**DELEGATED DECISION FOR APPLICATION FOR CERTIFICATE OF LAWFUL  
DEVELOPMENT**

Reference no.: 2024/CL/90666/W

Site: 3, Wall Nook Lane, Cumberworth, Huddersfield, HD8  
8YB

Description: Certificate of lawfulness for proposed alterations to  
existing dwelling

Proposed Site Layout
Scale 1:200

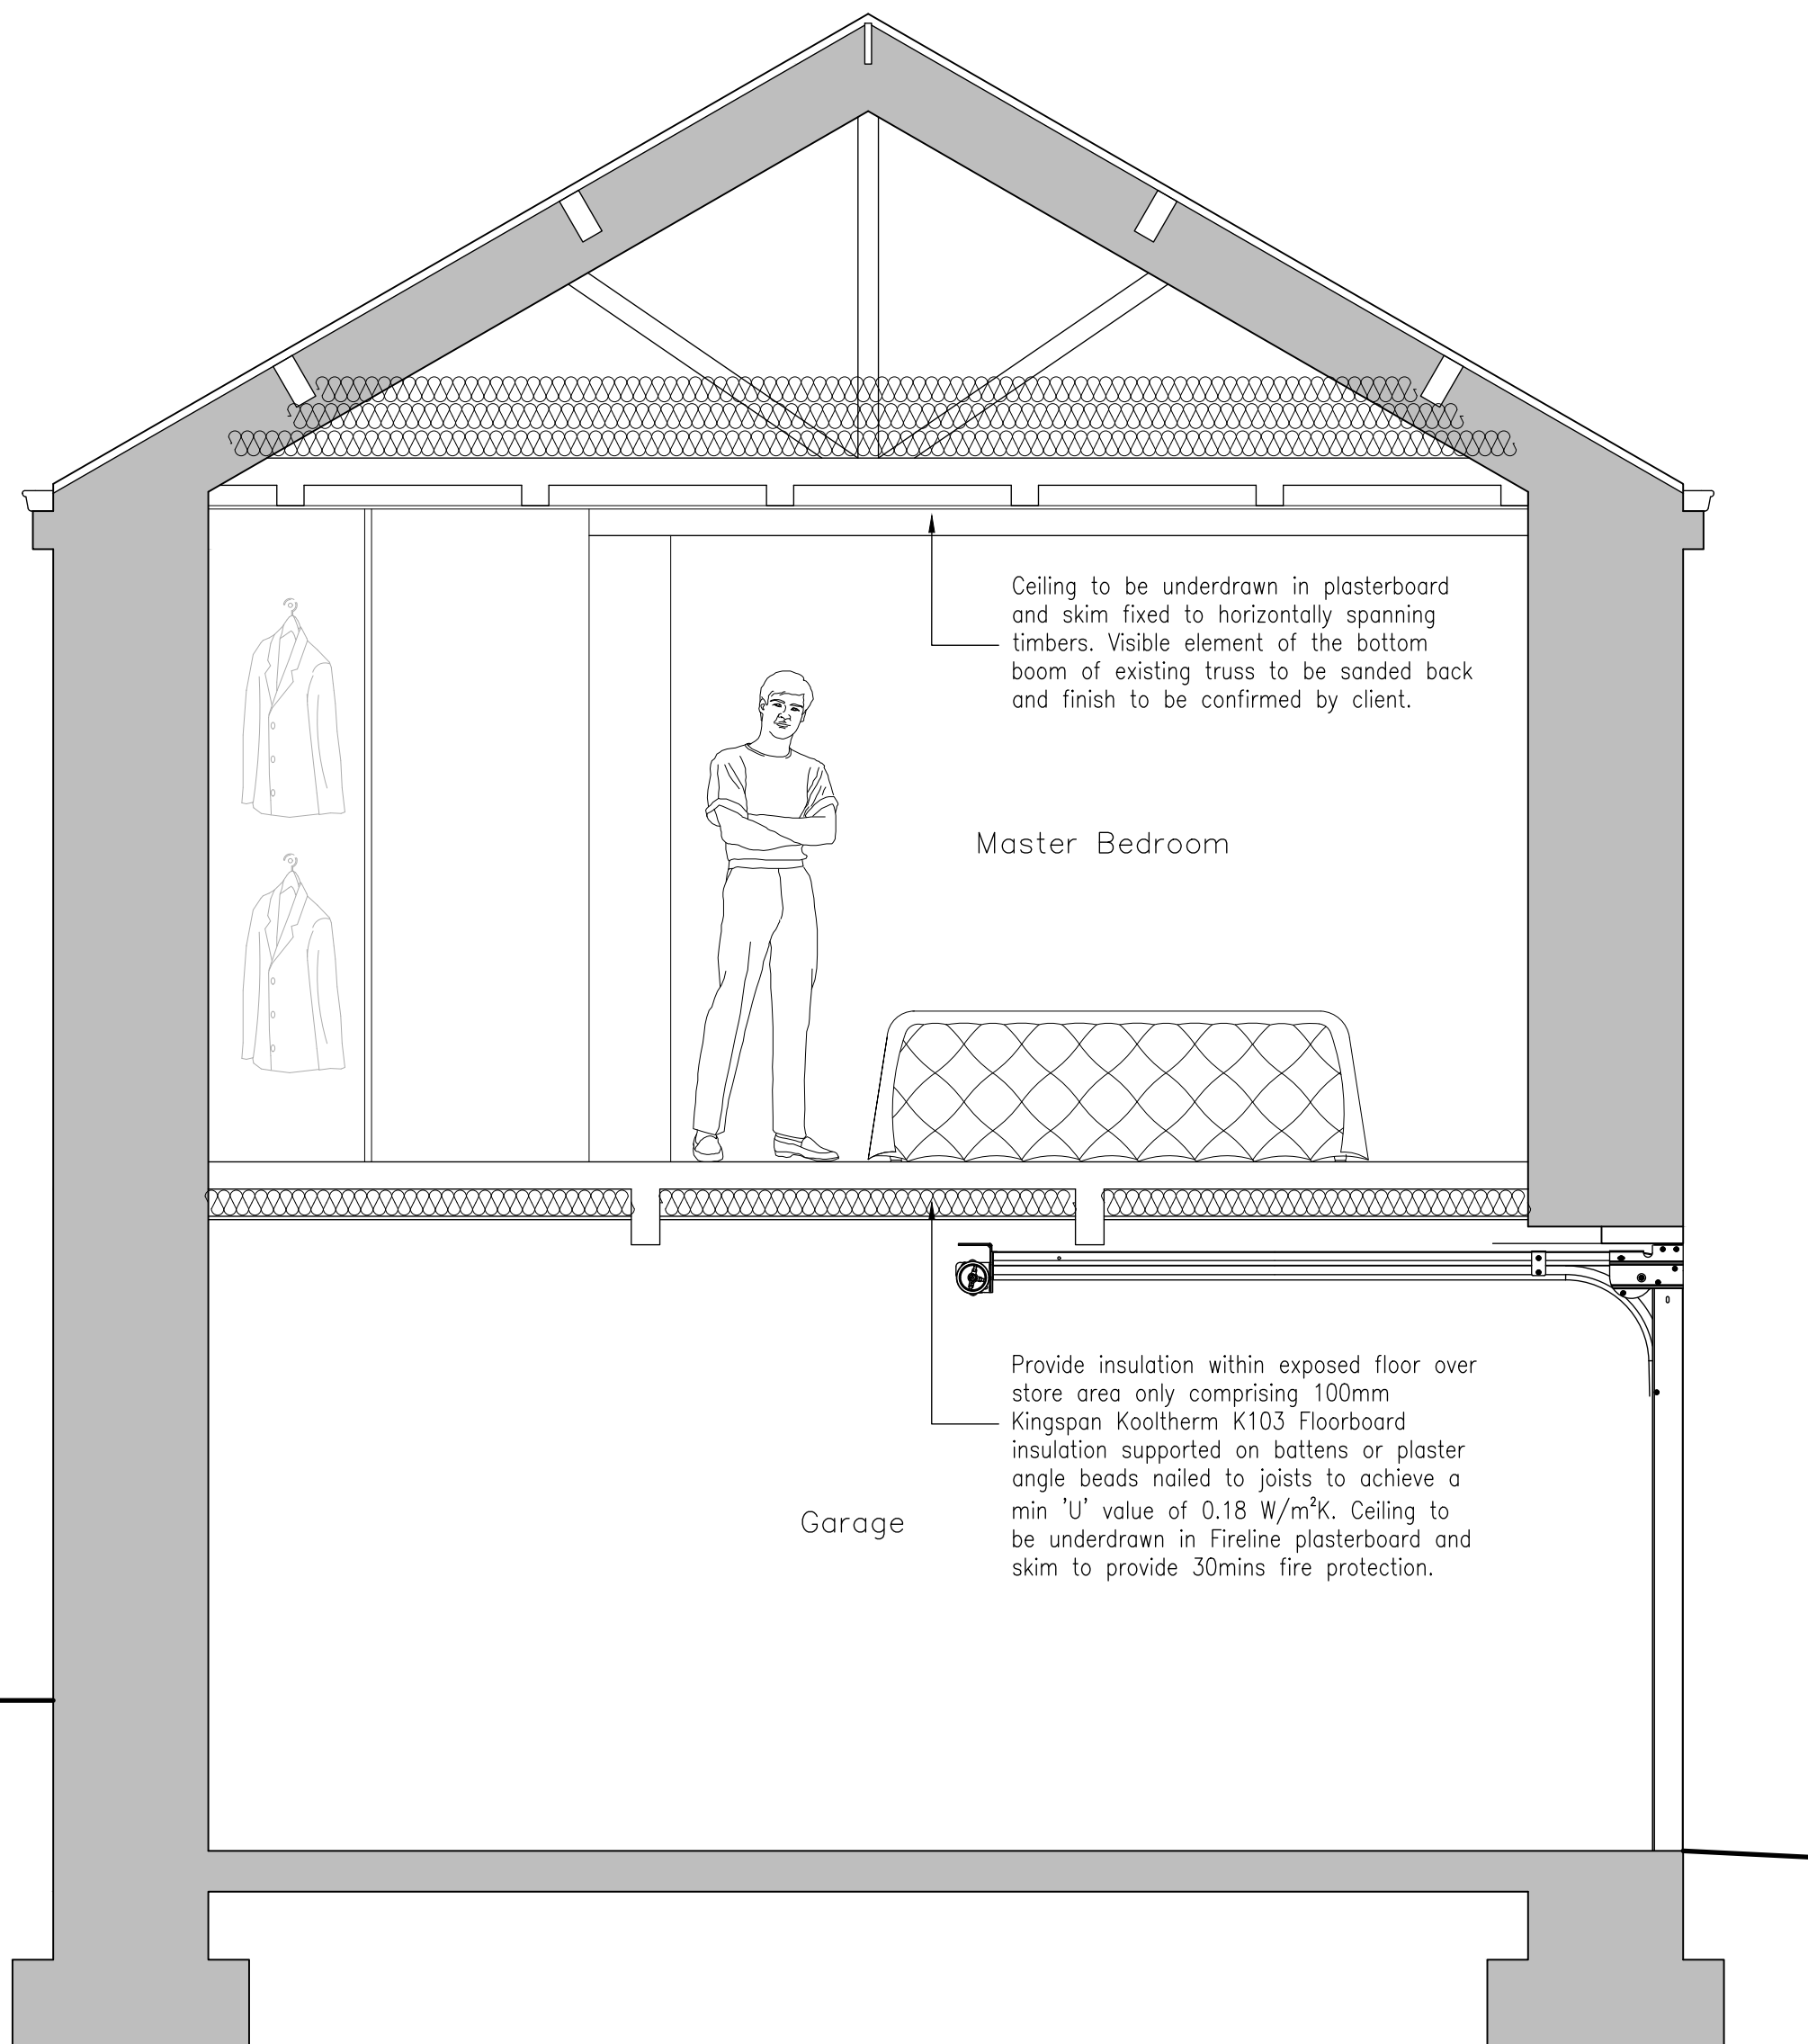
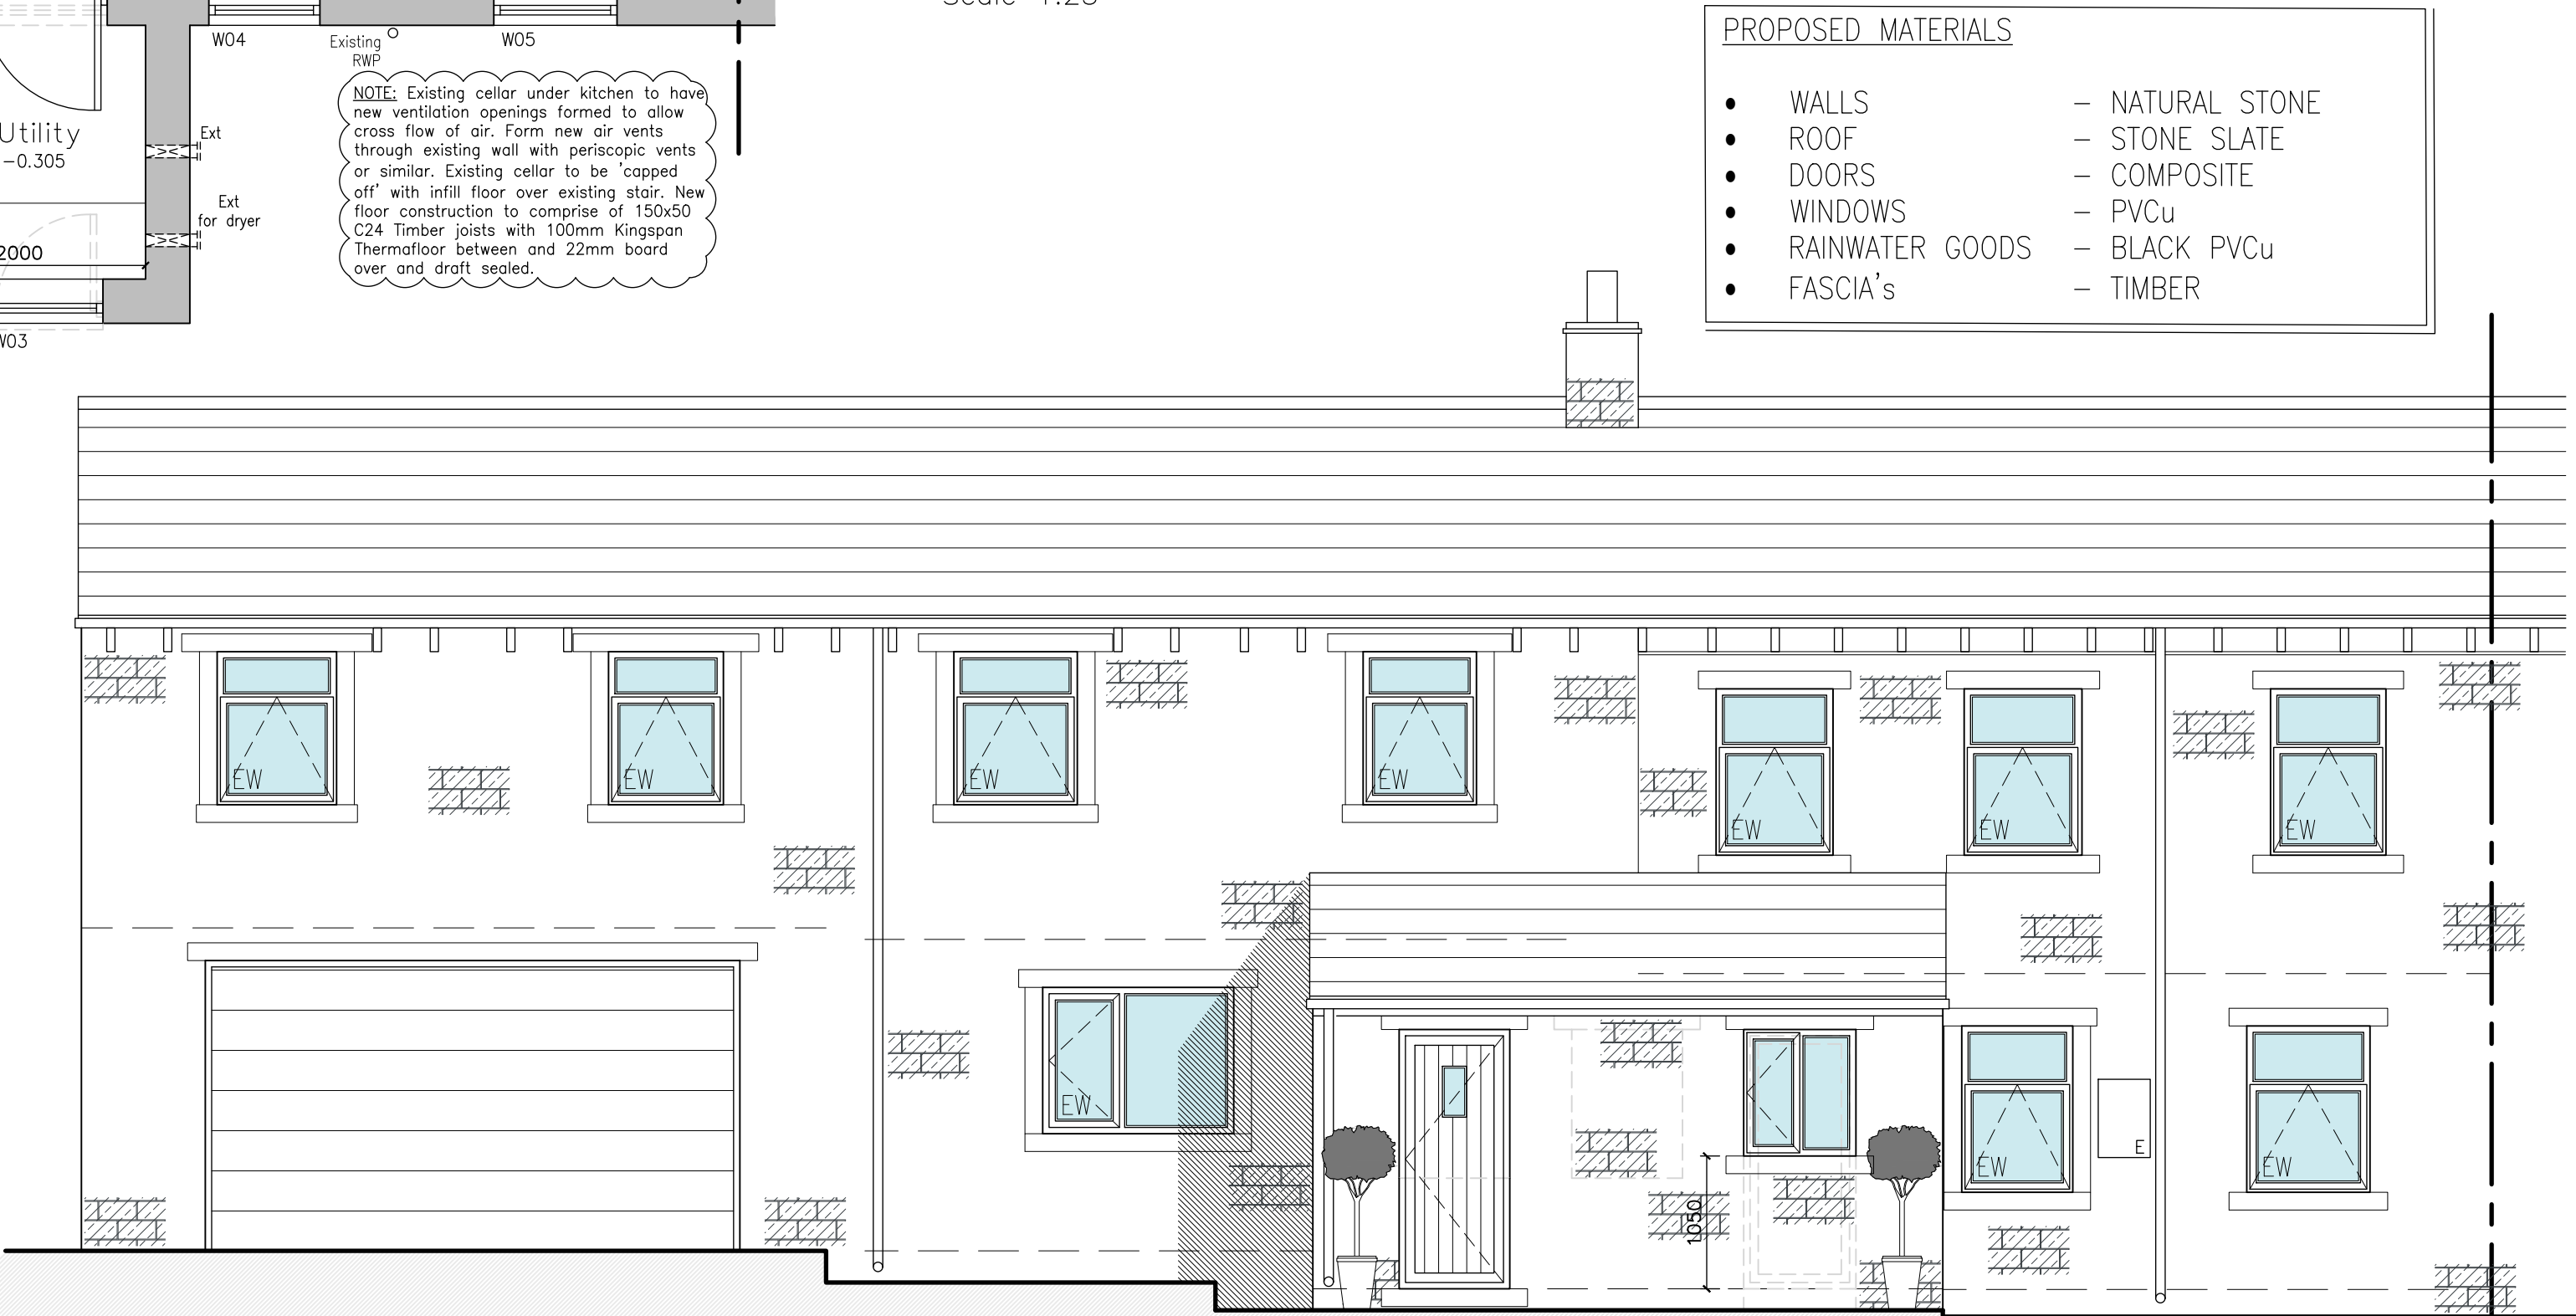
The proposal comprises internal alterations to form a master bedroom, en-suite, dressing room and office on the first floor and alterations to the flooring and addition of a new staircase on the ground floor. Additionally, it is proposed that the existing porch is divided to form a utility, which would result in the existing entrance door being replaced with a window and the existing porch window being made into the new main entrance. The timber windows are to be replaced by uPVC windows with the new first-floor en-suite and existing bathroom are to be altered so they are satin finish obscure glazing.

The proposed internal alterations to the dwellings are to affect only the interior of the building and the alterations to the existing openings do not materially affect the external appearance of the building. As such, the proposal is not regarded as being development as defined by Section 55 of the Town and Country Planning Act 1990.

The external alterations to openings and windows to composite doors and uPVC windows are likely to affect the appearance of the building to the degree the change in materials is likely to materially affect the character of the property. Permitted development rights under Class A may then apply.

granted under any class of Part 3, the heights of eaves and ridge are not altered and the development does not consist of any description of works in paragraph (k). Subject to materials matching the existing materials in appearance, the proposed external alterations benefit from permission granted under the provisions of the GPDO.

The proposed internal alterations as shown on plan 229-24-PL02 Rev C are not development as defined under Section 55 of The Town and Country Planning Act 1990 and the proposed external alterations to windows and door openings benefit from a general planning permission granted by virtue of Article 3(1) and Schedule 2, Part 1, Class A of the Town and Country Planning (General Permitted Development)(England) Order 2015 (as amended) subject to conditions as stated in paragraph A.3 of the same Order.
